Application for a non-material amendment following a grant of planning permission.
Town and Country Planning Act 1990

PROPOSED ERECTION OF DETACHED GARAGE WITHIN GARDEN CURTILAGE

3/2025/0455

PROPOSED GARAGE TO BE RE-LOCATED AWAY FROM ADJOINING BOUNDARIES

EXISTING AND PROPOSED SITE PLAN	
Site: Carniola Whins Lane Simonstone BB12 7QT	
Client: Mr Dylan Brown	
Date: 30.05.25	Scale: 1:200 @ A1
Project No: BR/01 Dwg 02	Drawn: DS
Amendments:

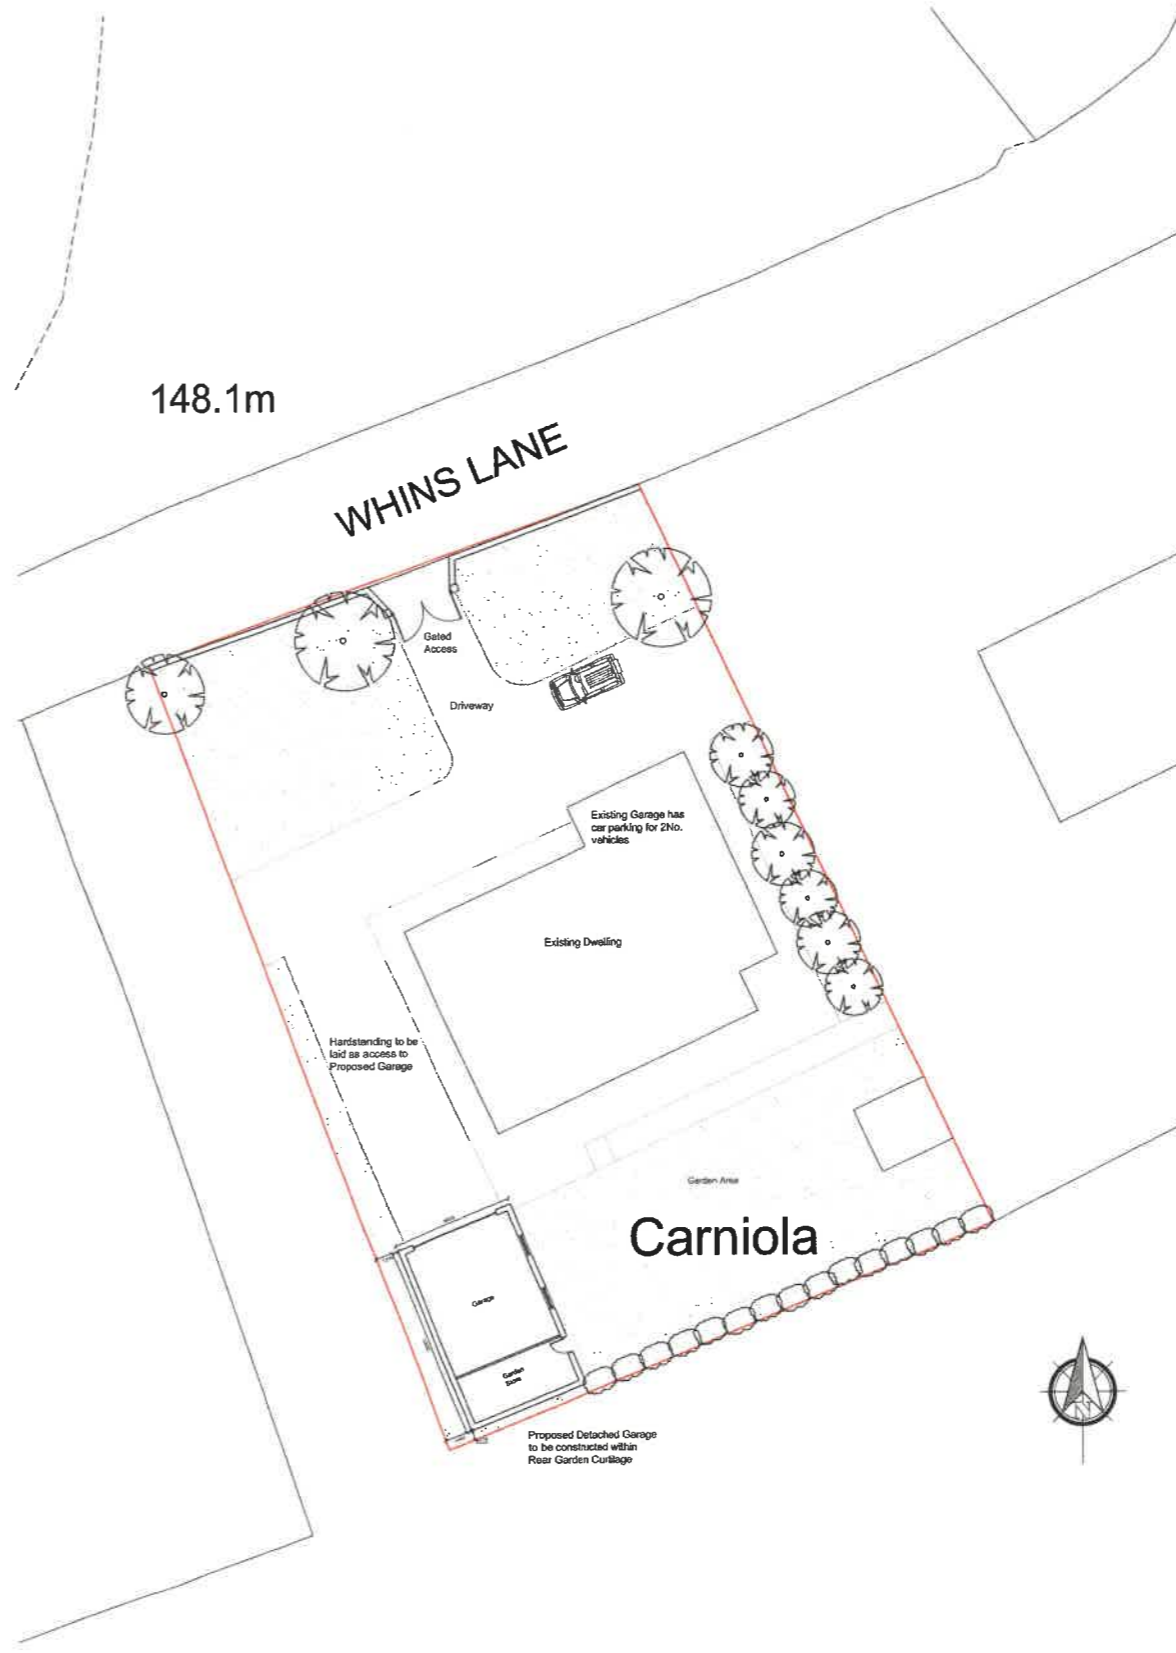
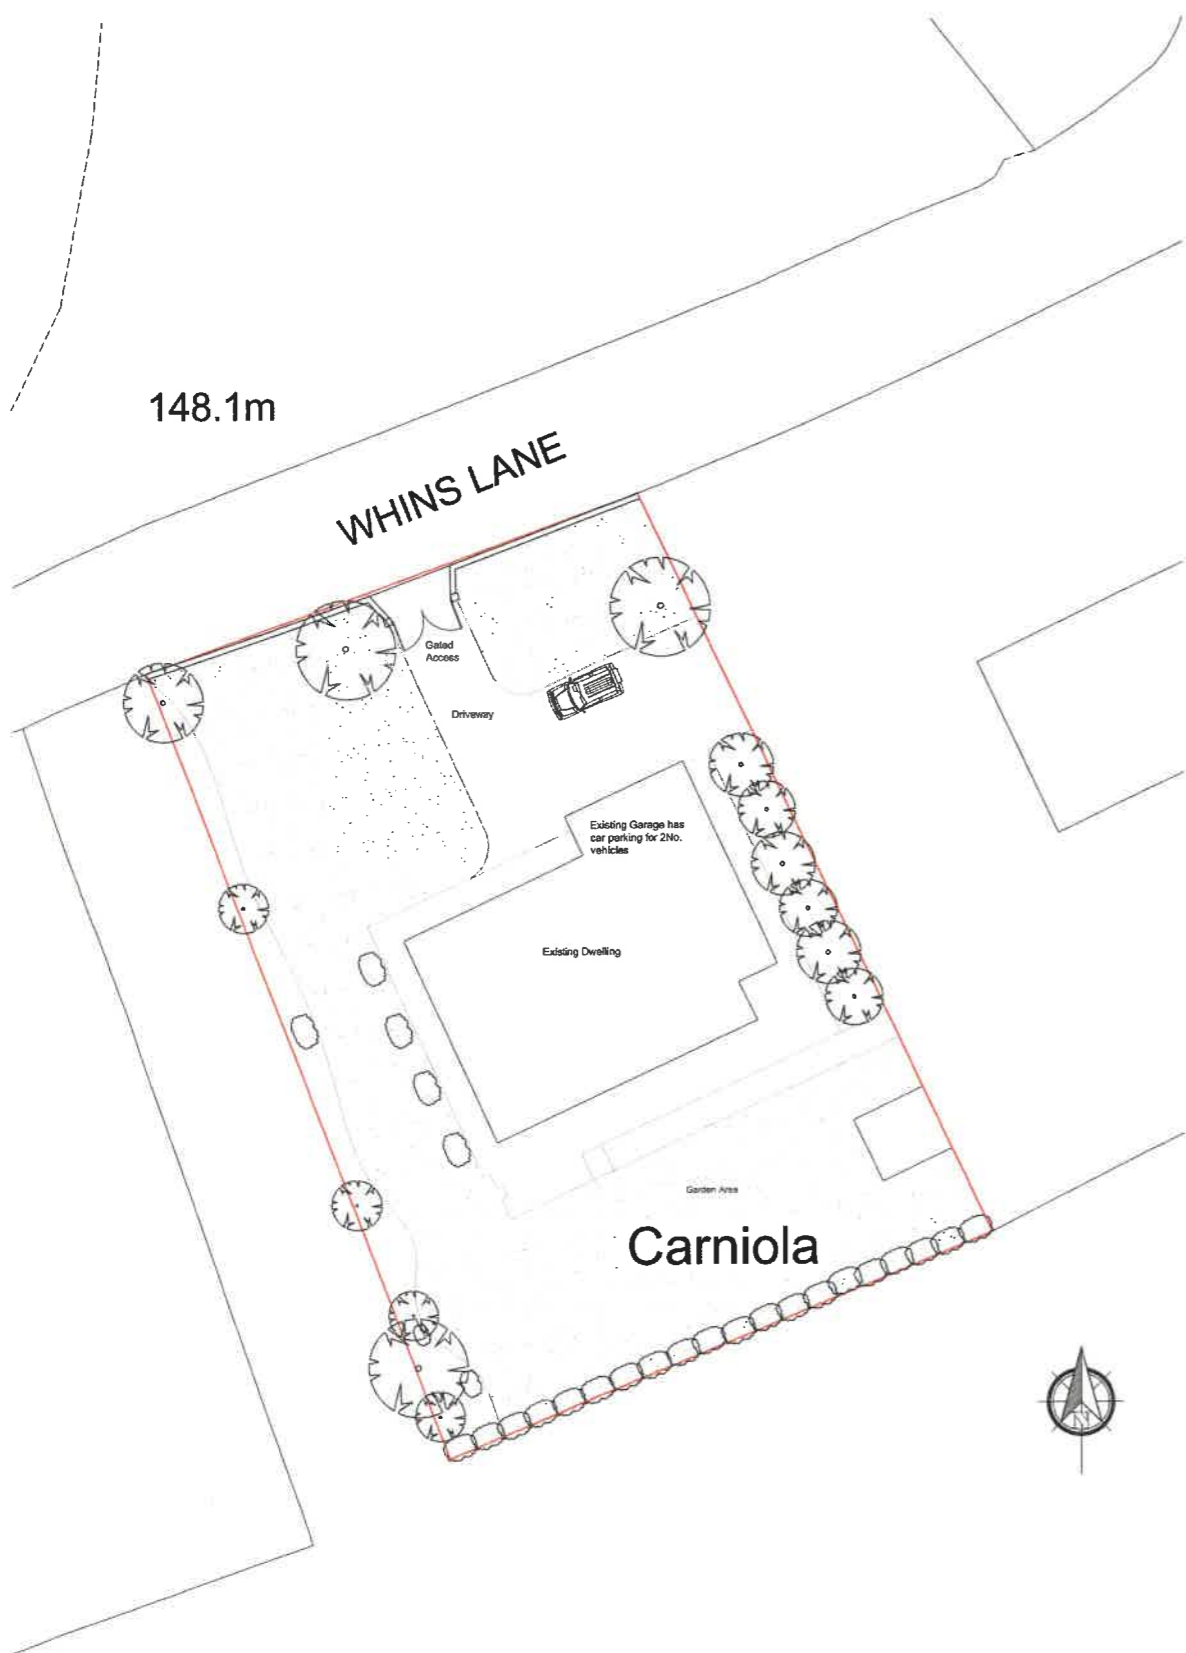
DWG 02 EXISTING AND PROPOSED SITE PLAN

DWG 02A EXISTING AND PROPOSED SITE PLAN

PROPOSED BUILDING TO BE RE-LOCATED AWAY FROM EXISTING BOUNDARIES SO AS NOT TO INTERFERE WITH EXISTING HEDGEROW PLANTING
